Rezoning Transportation Analysis

Petition Number: 2021-112

Date	Description
09-21-21	First Review (BKB)
11-29-2021	Second Review (PDM)

RZ-2: PARCEL IDENTIFICATION PLAN

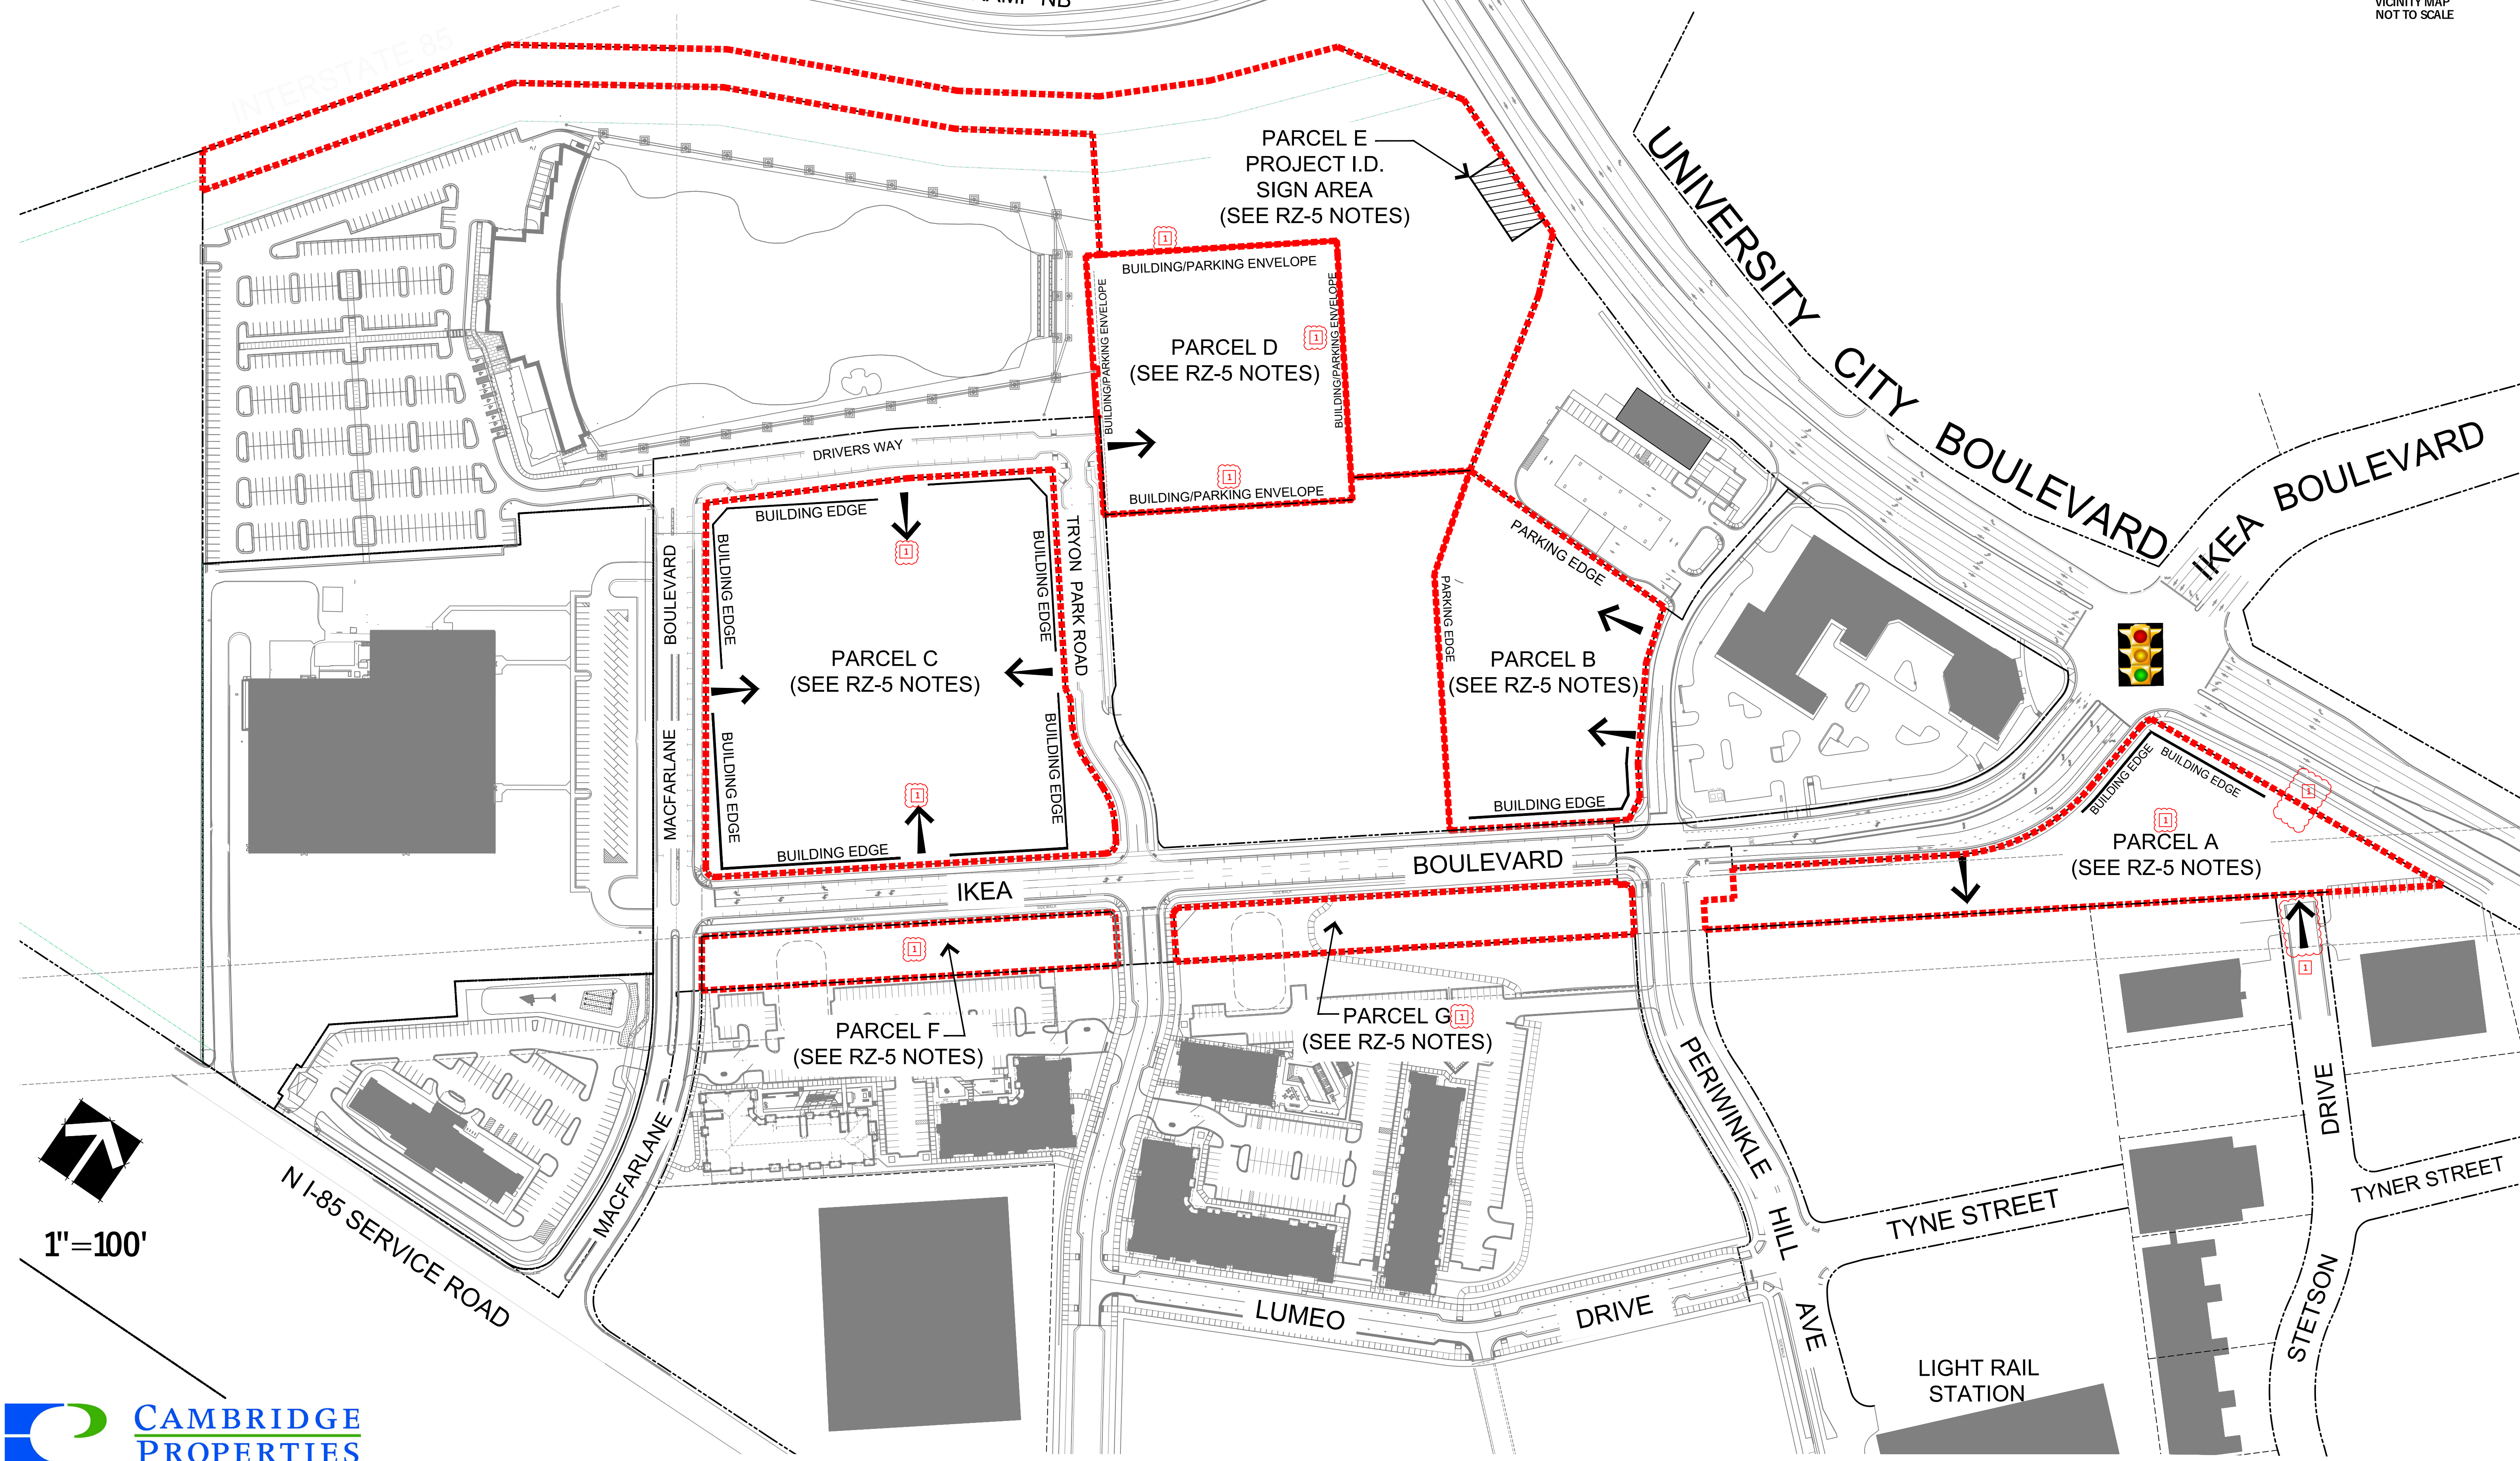
2. ~~Access points are not permitted off of University City Boulevard. Revise site plan and general notes to reflect the access point to Parcel A being off Stetson Drive as opposed to the currently shown access point on University City Boulevard.~~
